Interoffice Memorandum

January 18, 2016

Subject: Project # 1003450, Case # 15EPC-40029 – APD SE Area Command

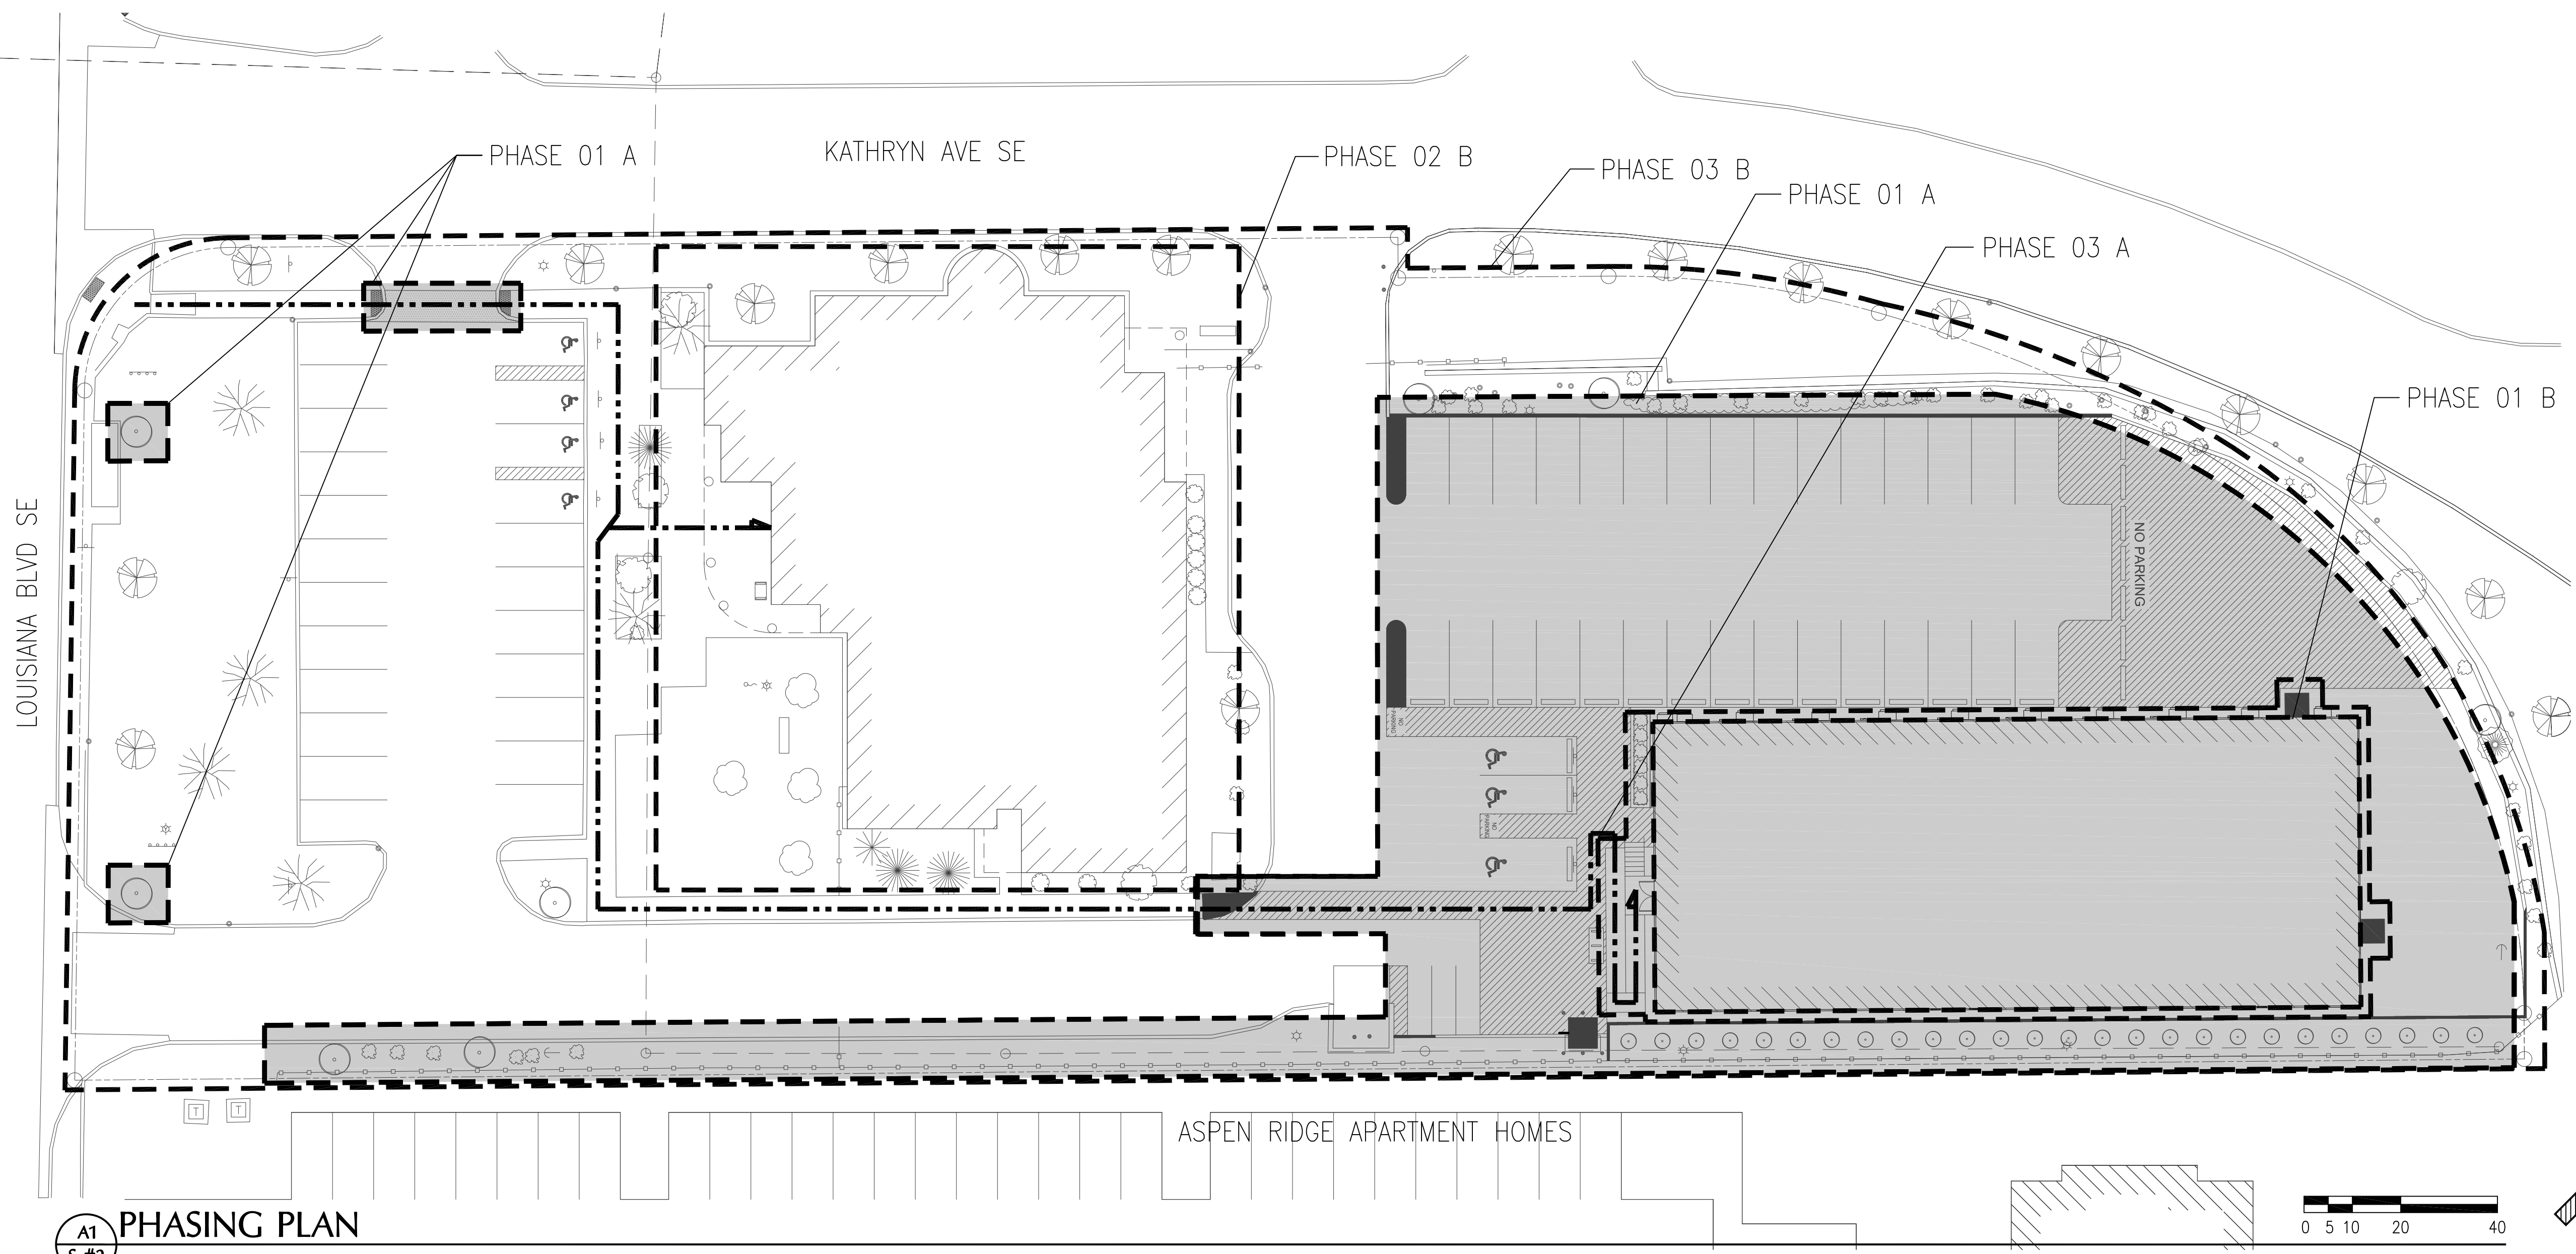
A minor, but helpful addition for our records would be the date of this revised site development plan in the lower right-hand box of Sheet 1.
